Comments for Planning Application 3/21/0094/CLPO

Application Number: 3/21/0094/CLPO

Address: 6 Bowlby Hill Gilston Hertfordshire CM20 2FZ

Proposal: Loft conversion with the insertion of 4 rooflights and window to flank elevation

PROPOSED NORTH EAST ELEVATION
1:100

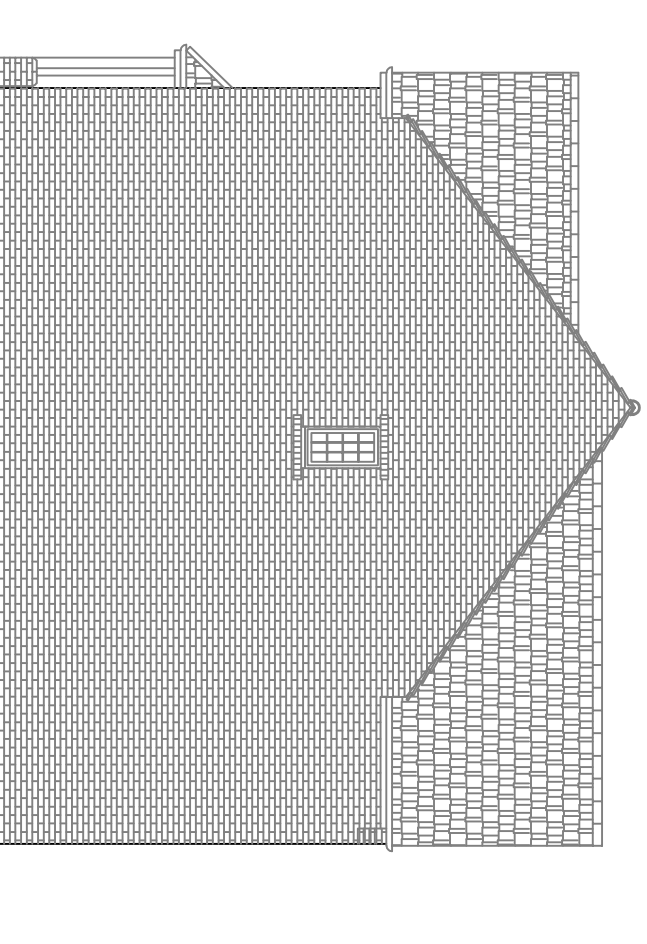
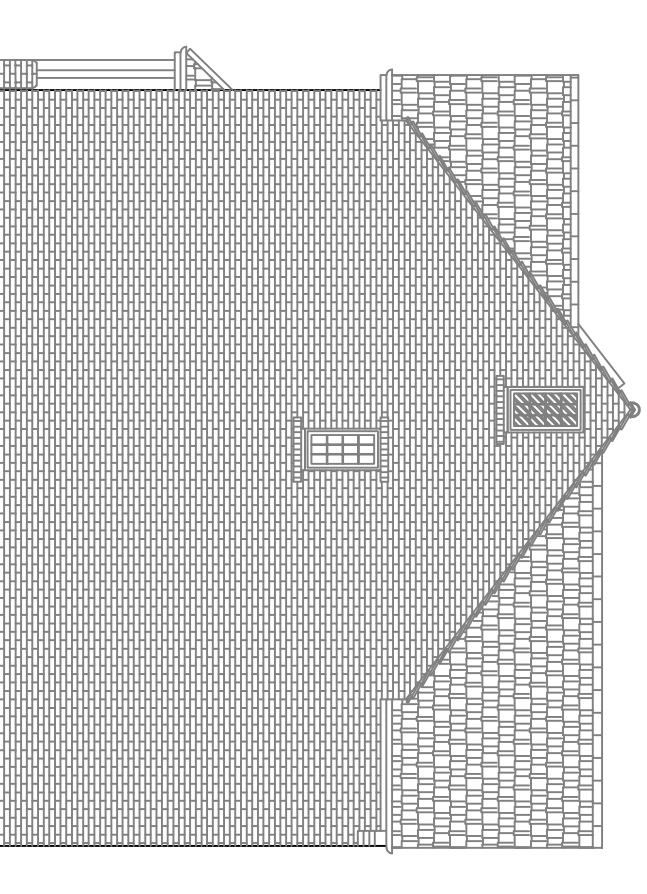
The new window on the North East elevation creates a new vantage point from which one can see into our bathroom, kitchen utility, studio above our garage, and back garden.

Our driveway is enclosed within three tall walls: the sides of #6 and #7, and the front of our double garage and studio. Sound echos within these walls, and noise coming from this window would reverberate easily.

The large driveway between #6 and #7 belongs entirely to us (#7), i.e. not shared with any neighbours. The two existing windows, i.e. the one on the side of #6, and the other on the side of #7, are at the same height and symmetrical. The new window would detract from the current visual amenity, and would look as if #6 overlooked a shared courtyard, which is not the case.

- (a) the window on the North East elevation will be a fixed window, i.e. the window will not open, and
- (b) the window will have obscured glass.

We confirm that we agreed to points (a) and (b). The applicants' architect has updated the plans accordingly, and submitted them to the East Herts Planning Office on Monday 25th January. Our understanding is that the Planning Office will update the planning application accordingly for the public records.
